CITY OF ALBUQUERQUE

January 24, 2025

**RE: Menaul & Vasser
2500 Phoenix Ave. NE
Grading & Drainage Plan
Engineer's Stamp Date: 01/03/2025
Hydrology File: H16D156**

MENAU AND VASSAR
 2500 PHOENIX AVE NE, ALBUQUERQUE,
 NM, 87107
GRADING AND DRAINAGE PLAN

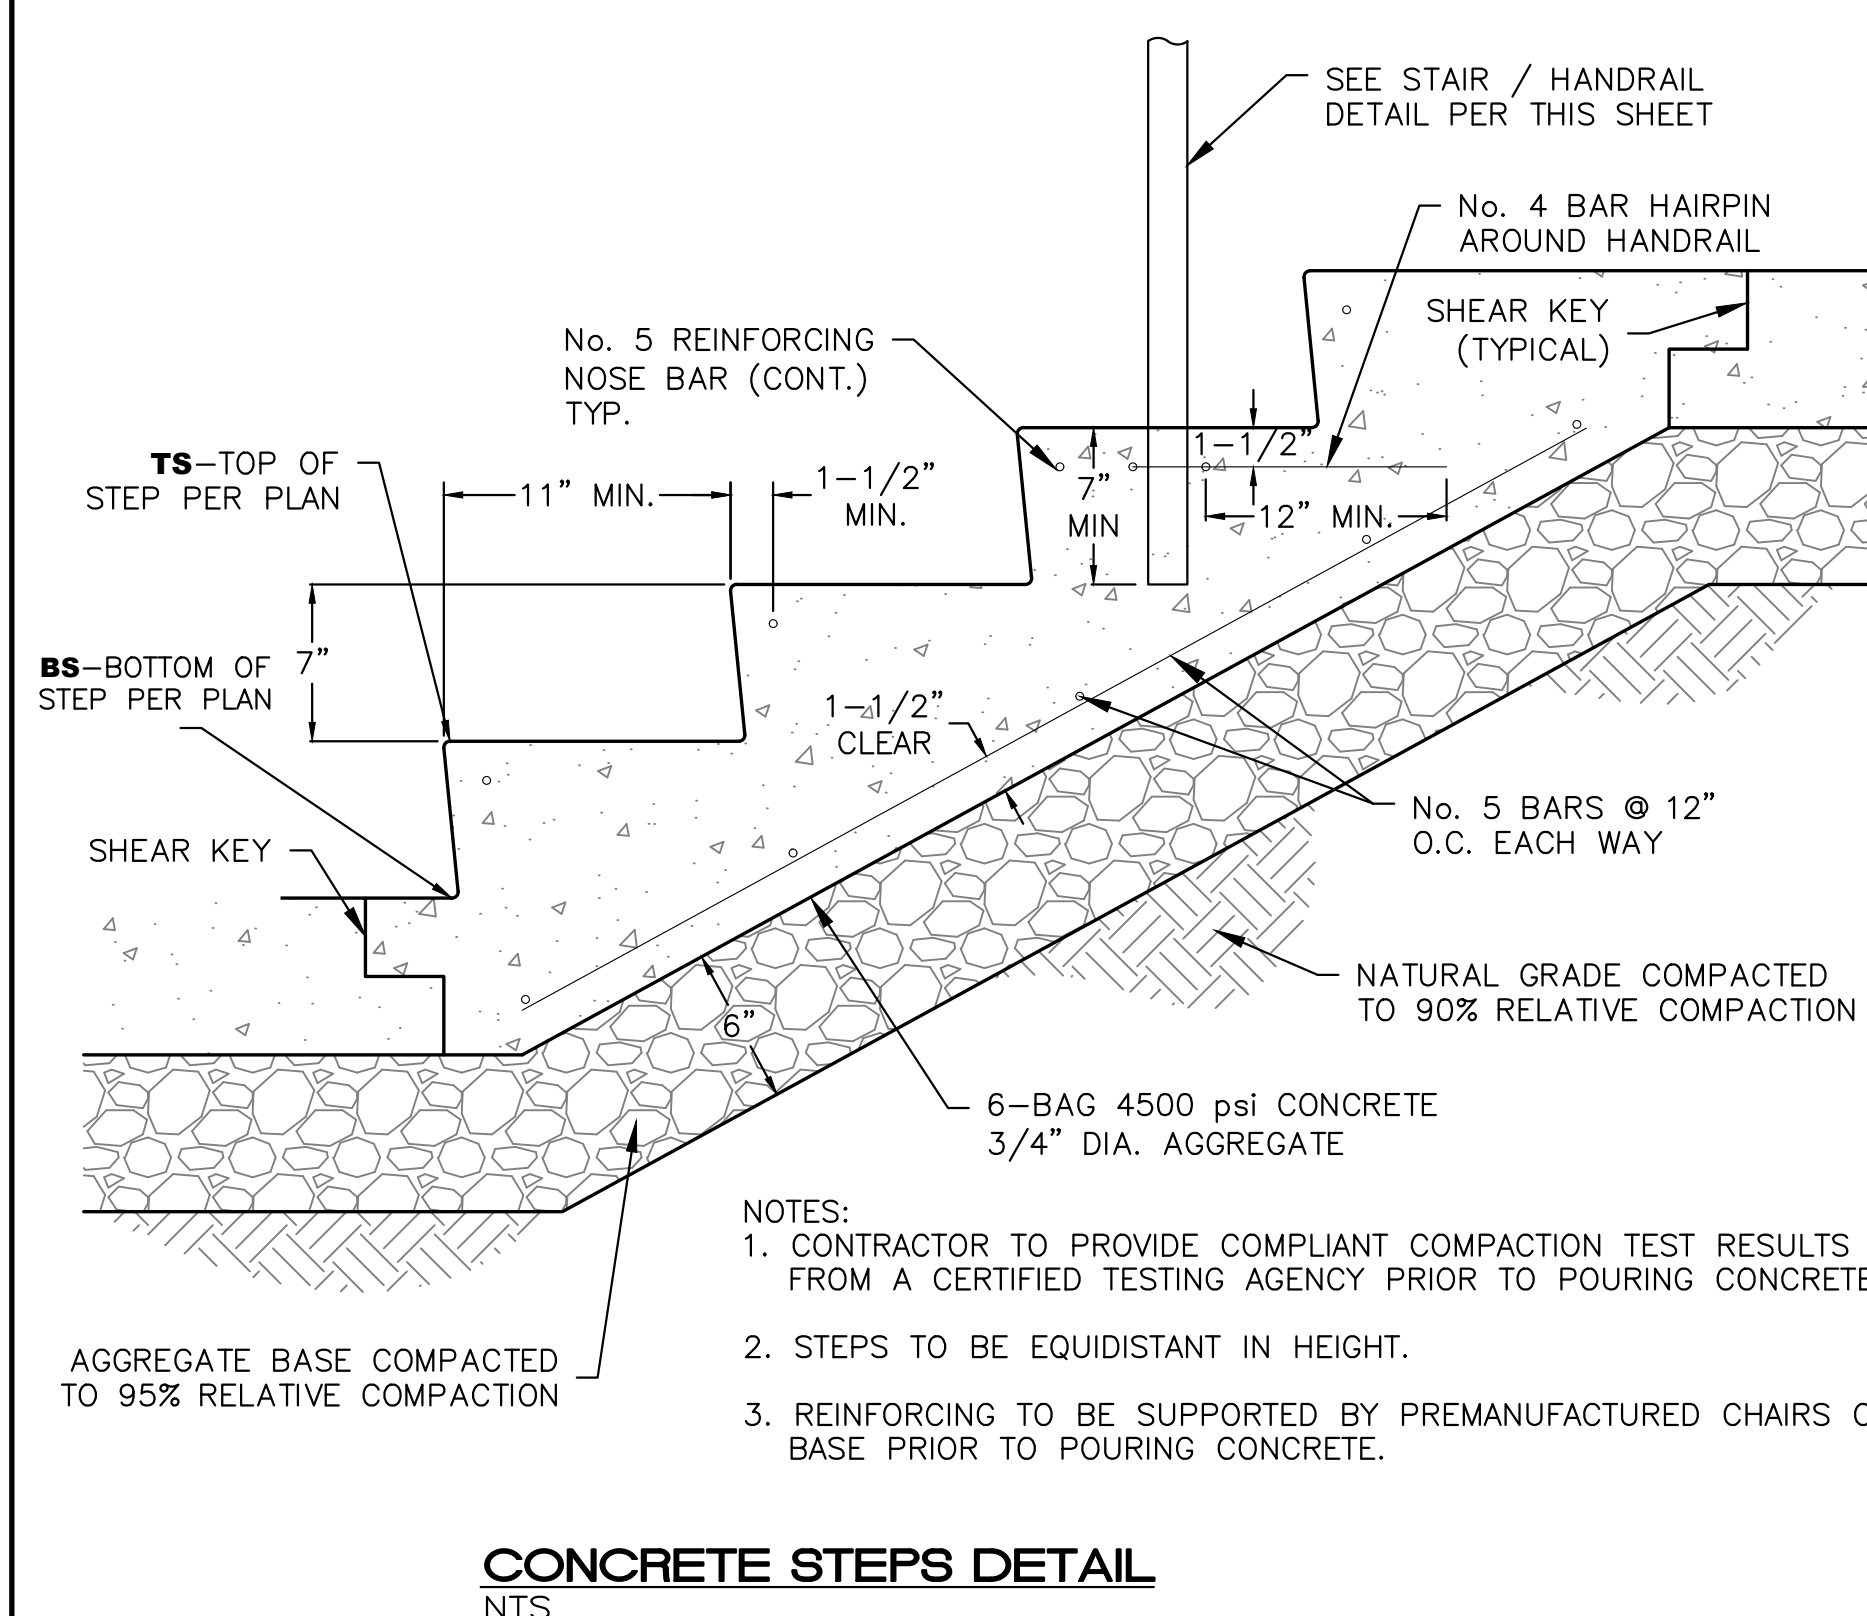
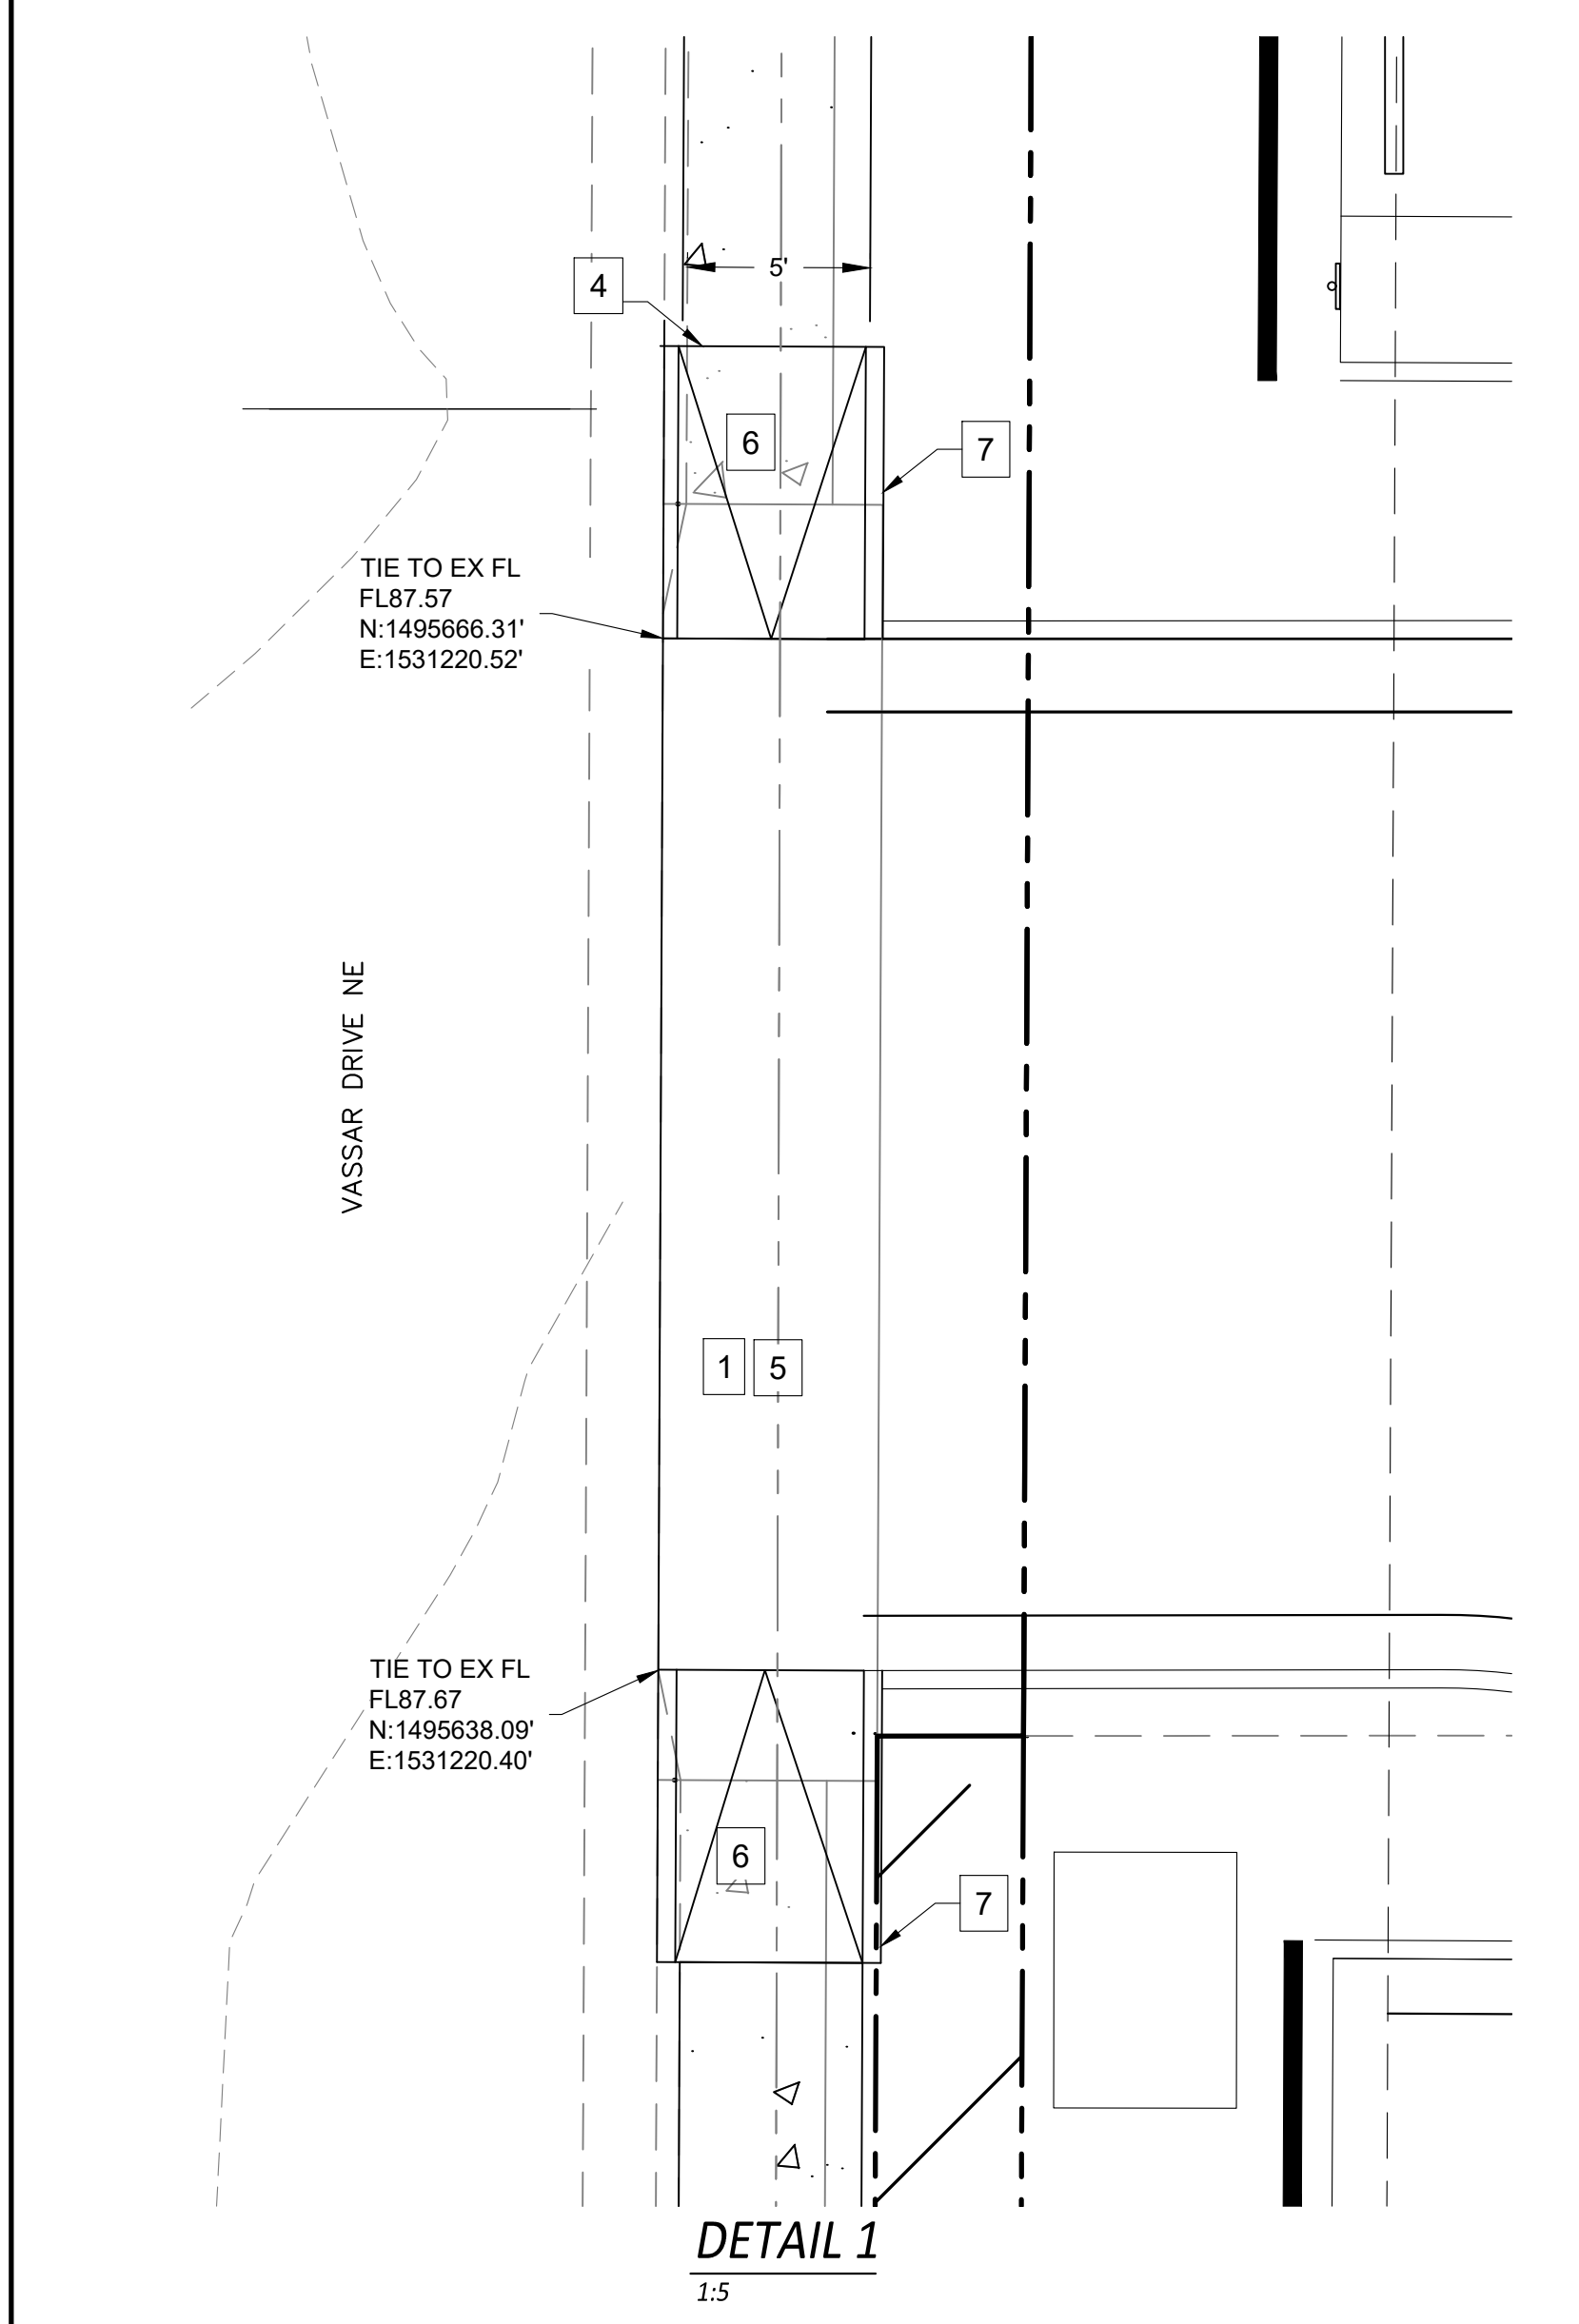
1. Sheet C2.0: Review and revise Section A-A to include the existing the storm drain grated inlet along Phoenix Ave.
2. Sheet C2.0: Review and revise Section B-B to include the existing concrete curb along the westerly boundary of 2600 Phoenix Ave. SE.

3. Sheet C2.0: Review and revise Section B-B to include the proposed pavement surface shown at the easterly side of said Section B-B on the plan in lieu of the proposed landscaping surfacing shown in the Section.

4. Sheet C2.0: For stormwater drainage purposes, Sections B-B and C-C should be reviewed for surface material types. Collecting and discharging stormwater from gravel surfaces onto a concrete valley gutter are rarely successful, and asphaltic pavement should be considered for all stormwater runoff areas.

5. Sheet C2.0: For stormwater drainage purposes, Sections D-D should be reviewed and revised to show the proposed 2-foot valley gutter leading north toward Phoenix Ave. per the Proposed Condition for Basin P1 stormwater runoff.

6. Sheet C2.0: Review and revise all Legend and Plan information and depictions regarding Base Course and Gravel.
7. Sheet C2.0: From field observations, the existing 30' Private Access and Drainage Easement appears to have an existing asphalt surface continuous to the property/parcel to the east. For stormwater drainage purposes, consideration should be given to maintaining this type of surface treatment in lieu of the proposed gravel surface.

8. Sheet C2.0: From field observations, the existing 30' Private Access and Drainage Easement appears to be providing access to the property/parcel/business to the east of this project which would be adversely affected by the proposed retaining wall, both for vehicular access and stormwater conveyance.

EXISTING BASIN MAP

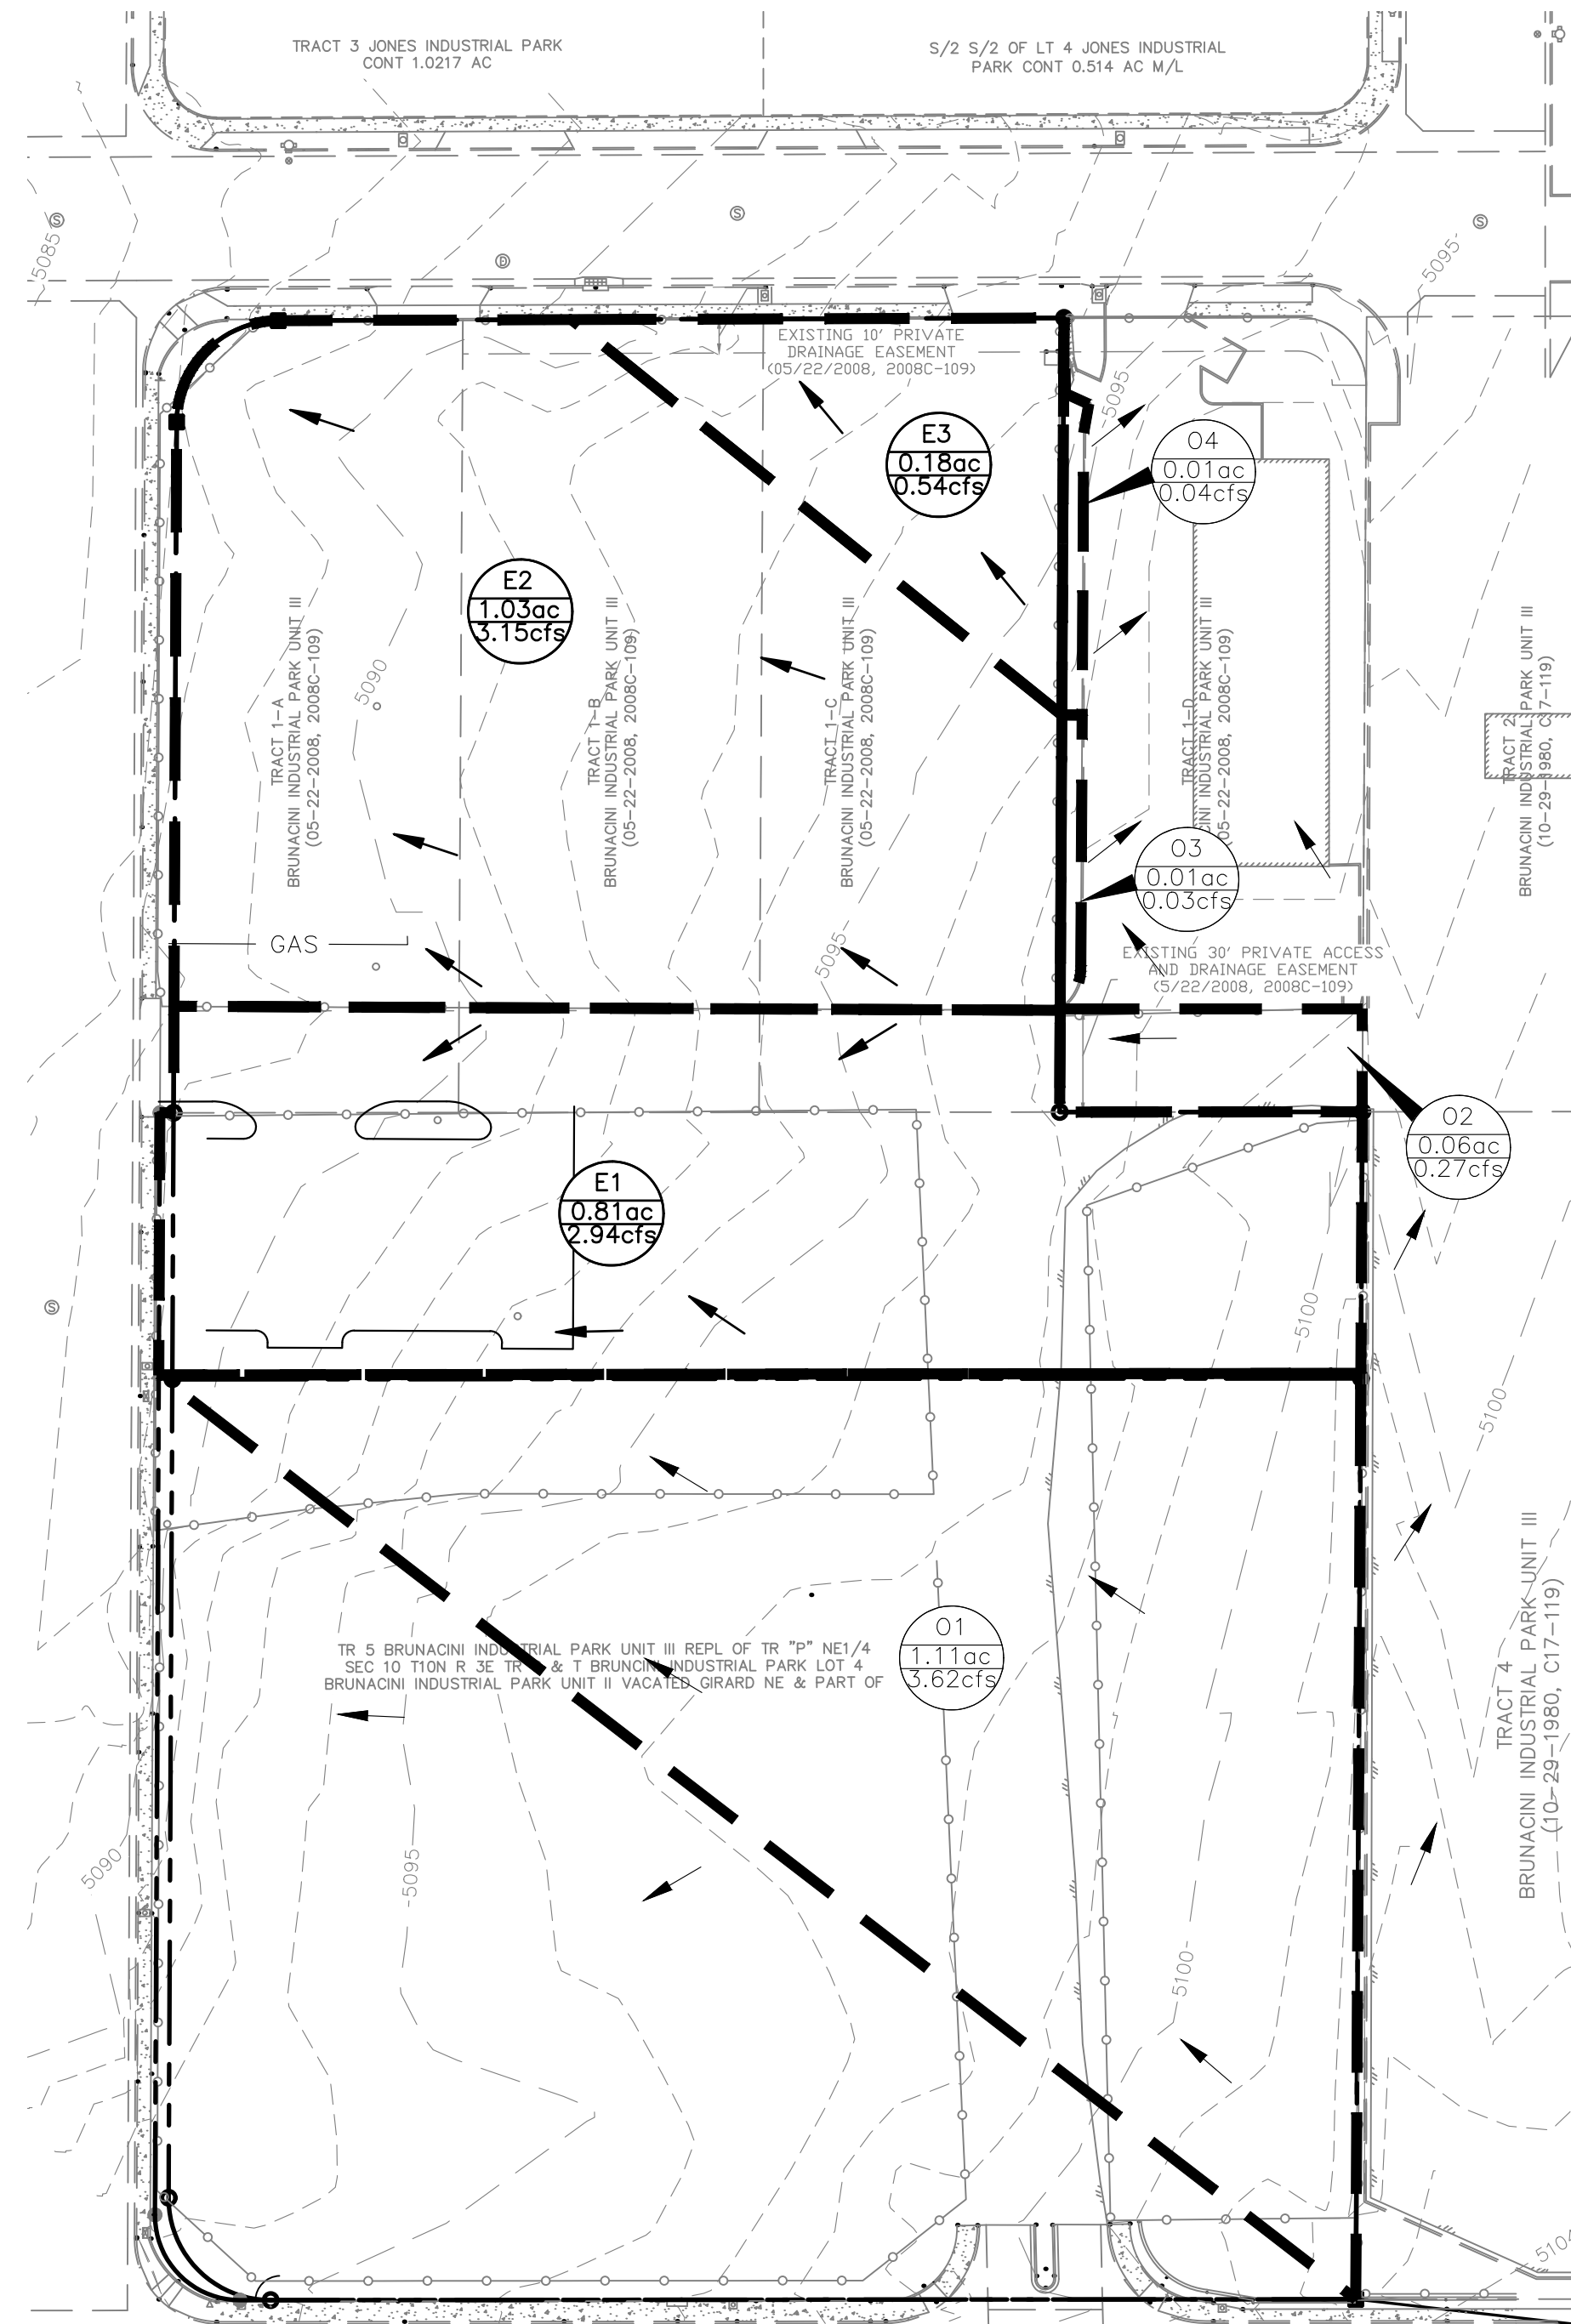
9. Sheet C2.1, The Existing Basin Map: From field observations and topographic mapping review, said Existing Basin Map should be reviewed and revised to reflect actual existing conditions.

10. Sheet C2.1, Existing Conditions: From field observations and topographic mapping review, Basin E1 should be reviewed and revised to more accurately document the existing fall from the southeast to the northwest, together with all appropriate calculations for determining c.f.s. for a 100-yr. storm.

11. Sheet C2.1, Existing Conditions: From field observations and topographic mapping review, Basin O1 should be reviewed and revised to more accurately document the contributing drainage area and existing fall from the southeast to the northwest, together with all appropriate calculations for determining c.f.s. for a 100-yr. storm.
